Our ref.: MP10_0173

Subject: Exhibition of Central Coast Cancer Centre (MP10_0173)

■ **Figure 1: Newly Created Parking Spaces (Refer STH Drawing DoP15)**

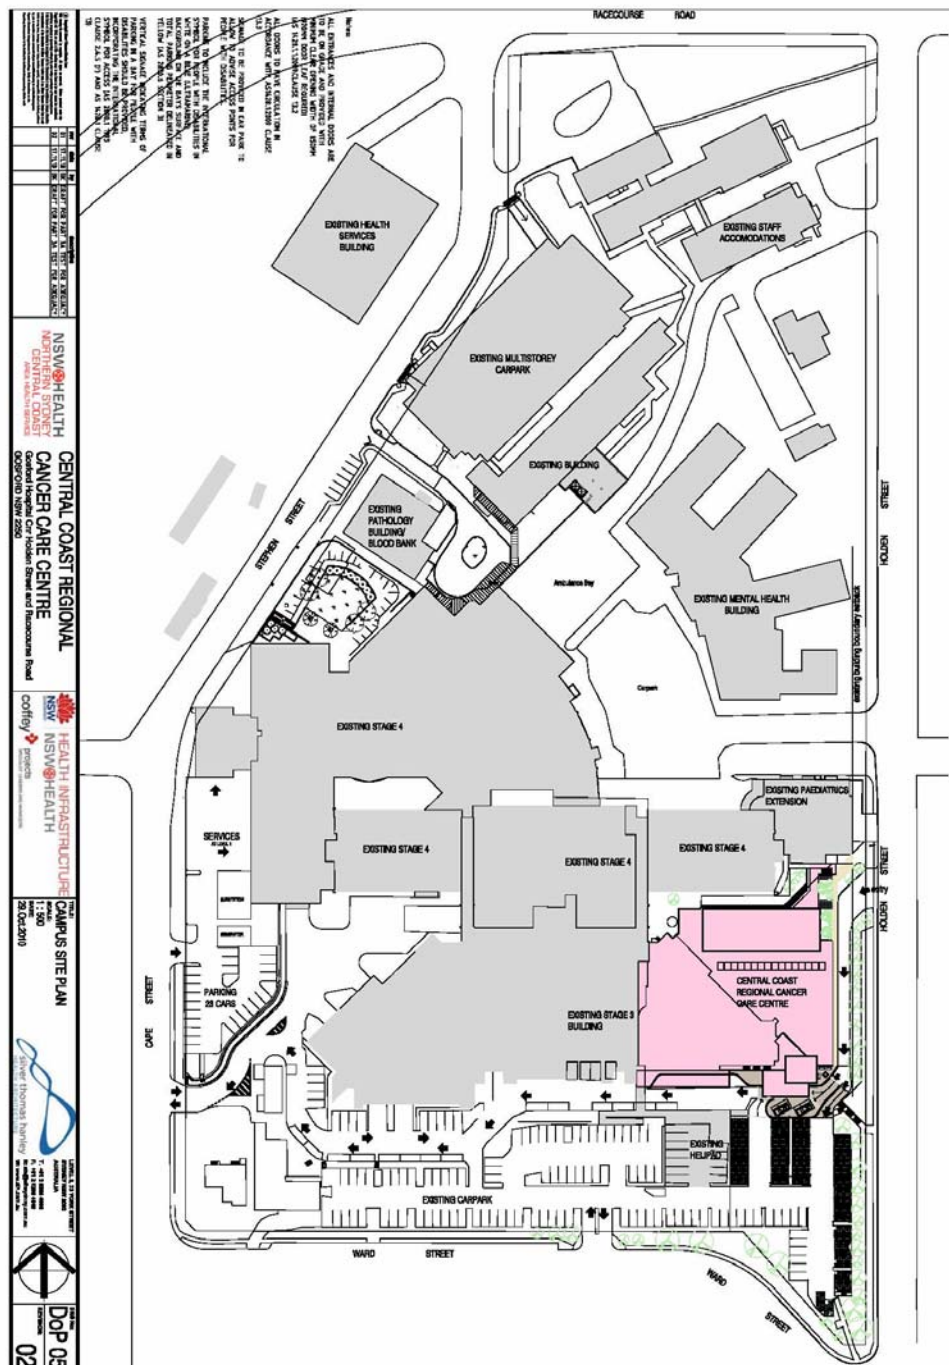
The Department has also reviewed the EA and, in addition to addressing the points raised within submissions received by the Department during exhibition, it is requested that you provide further clarification on the proposed car parking arrangements and impacts associated with the development of the proposed five new car parks. Further, the submitted Traffic and Transport Report, prepared by SKM, dated 16 November 2010, details different figures for the total number of new car parking spaces to be provided, which will require clarification.
